Recommendation: Refuse

Proposal: Certificate of Lawfulness of Proposed Development for the erection of single storey side and rear extensions to an existing house

Moorhouse, Church Lane, Wendlebury, OX25 2PN

Moorhouse, Church Lane, Wendlebury, OX25 2PN.  
 Proposed extensions & alterations.  
 PROPOSED FLOOR PLAN & SECTION B - B, scale 1:50  
 P3077/14  
 copyright 2021 Selwyn Palmer Architects  
 01494 881273  
 selpalmerarchitects@gmail.com

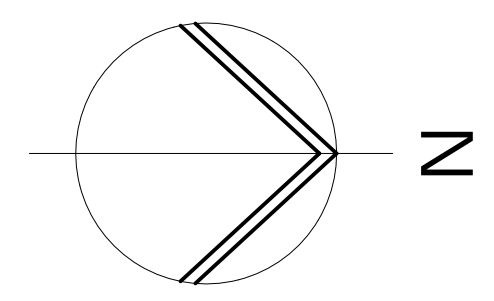
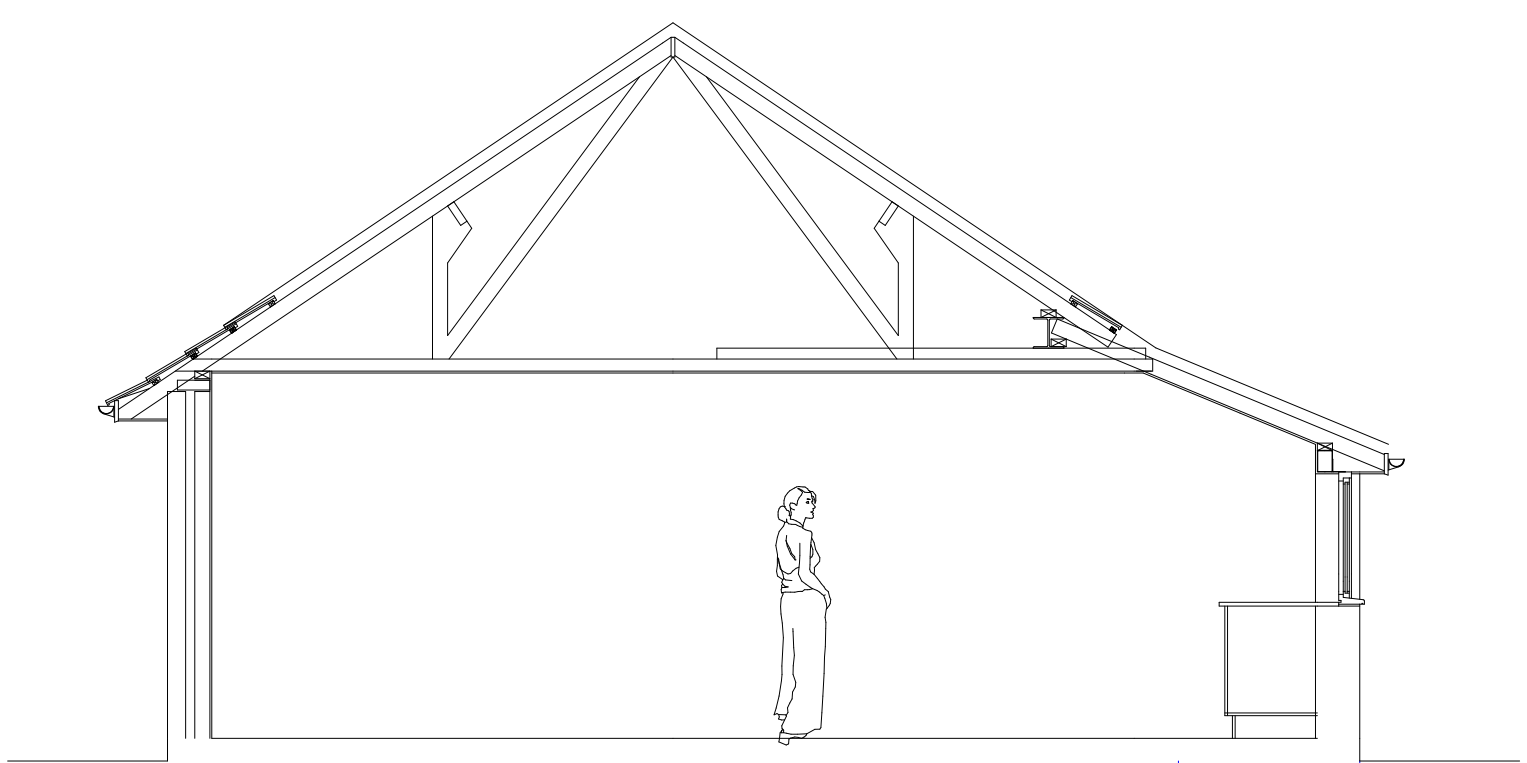
8.12. Notwithstanding the agents calculations (3.67 sqm) the proposed would not exceed 3 square metres (measured externally).

P3077/17

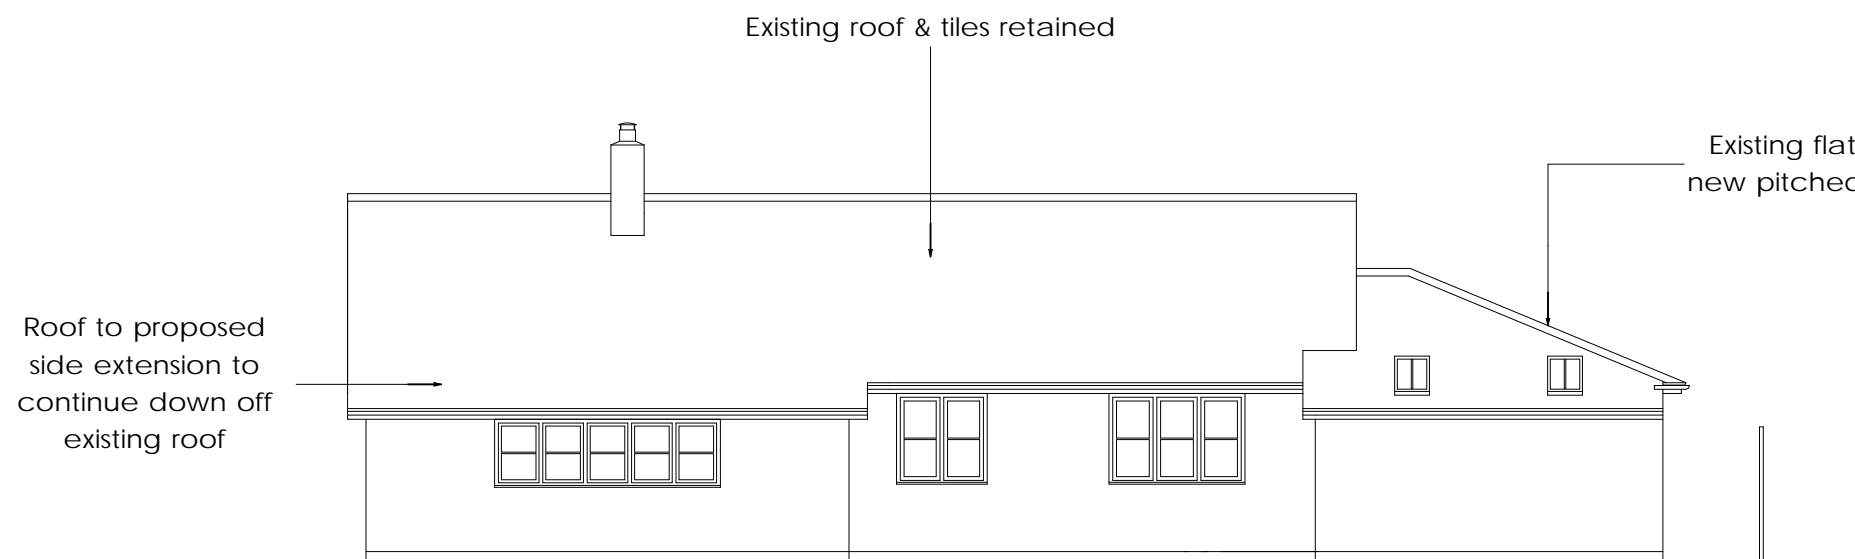
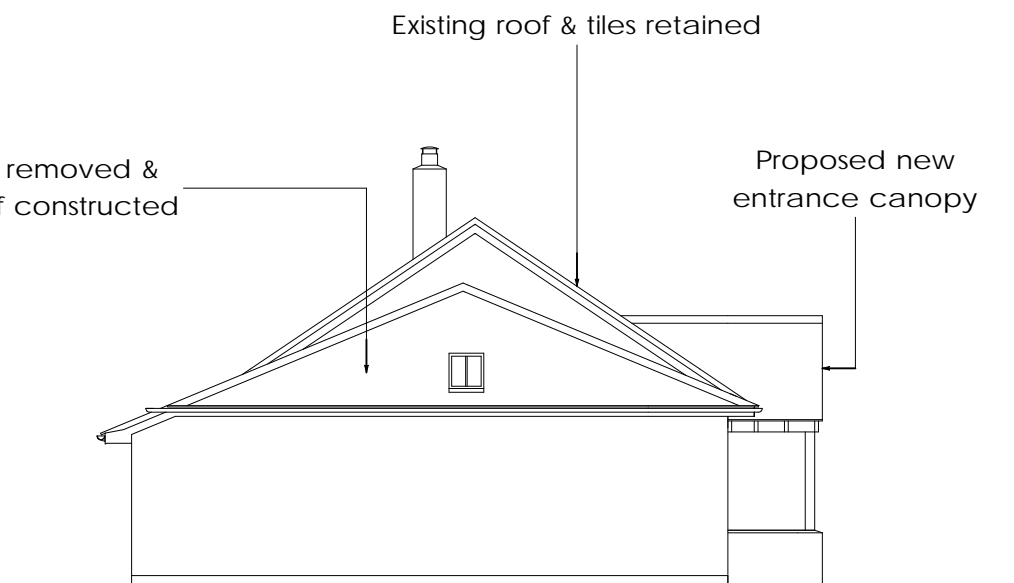
8.13. The structure would exceed 3 metres above ground level.

The development is not permitted development under Schedule 2, Part 1, Class D of the Town and Country Planning (General Permitted Development) (England) Order 2015 (as amended) because the height of the porch would exceed 3 metres.
